Dawn Muscat 101
3 Cooper St, Paddington
14th December 2010.

2-Scottish Hospital

Ref 10 @ 160 File 10/03532-1

DRAWING TITLE  
**Gate Keeper's Lodge - Unit Plans - Sheet 1**  
DRAWING No  
DA 464

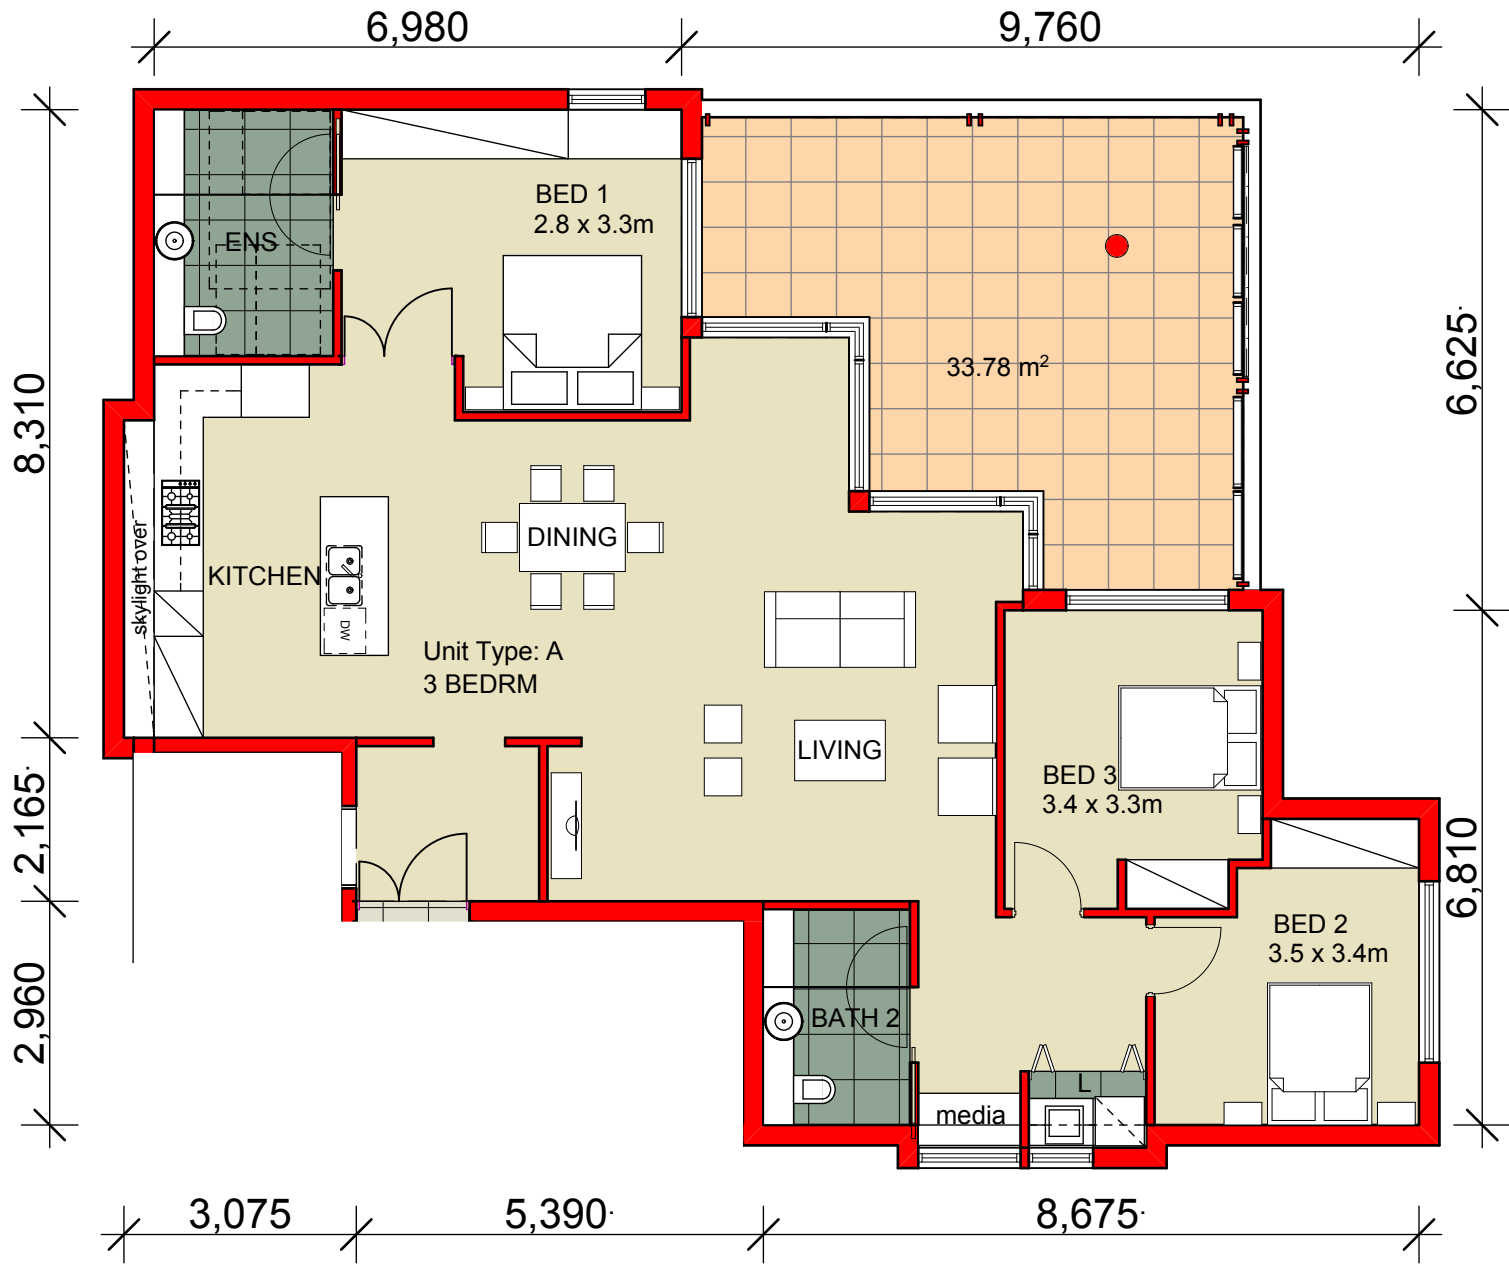
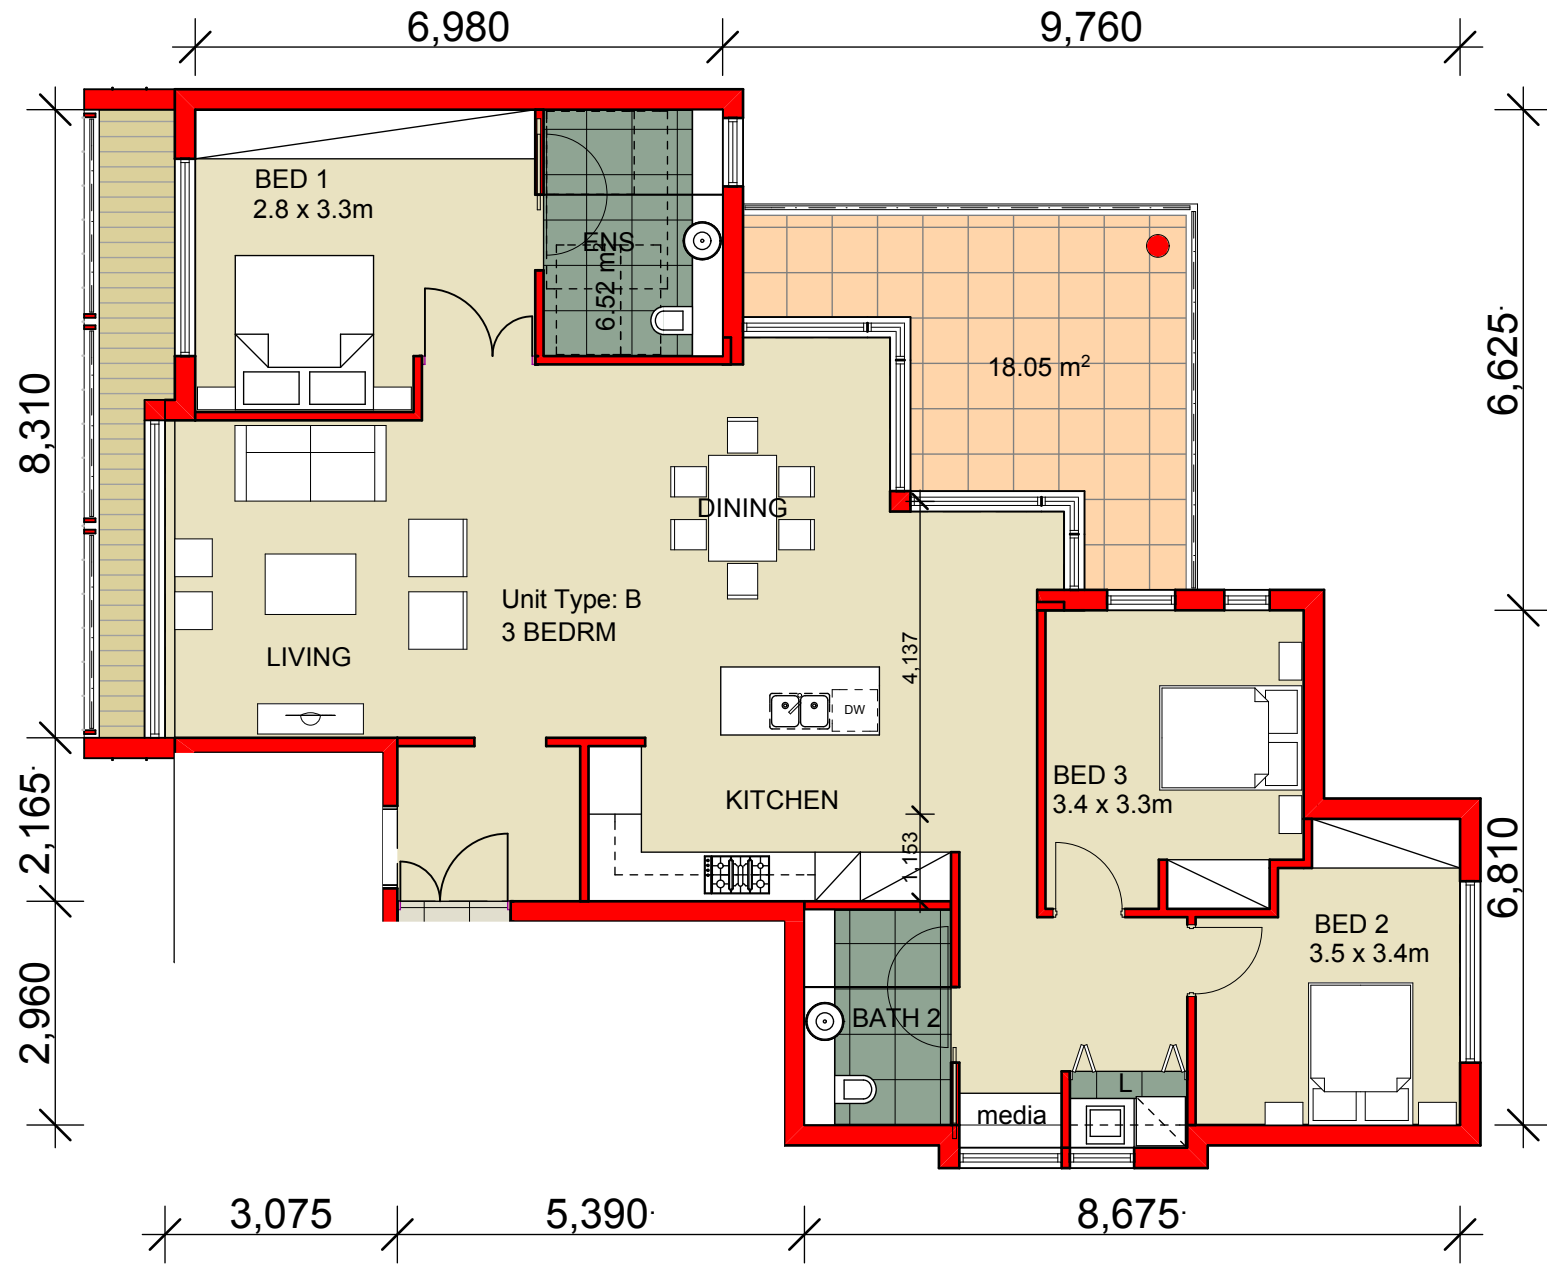
- Cooper St, for these RESENA once I myself
could not walk from the front door is in
Cooper St, would you?
would like the GATE KEEPER LODGE COMPLETEY
MOVED from Cooper St, least end, next to the Blues
at Brown and Cooper St.
are are two trees I noticed on the plan that
are in great danger. NO 100 north Island Pine
Cooper St and 119 lower down the block look at
an, not good news. A IMPACT REPORT will
it help once the damage is done, once the
EMENT is down its DOWN.
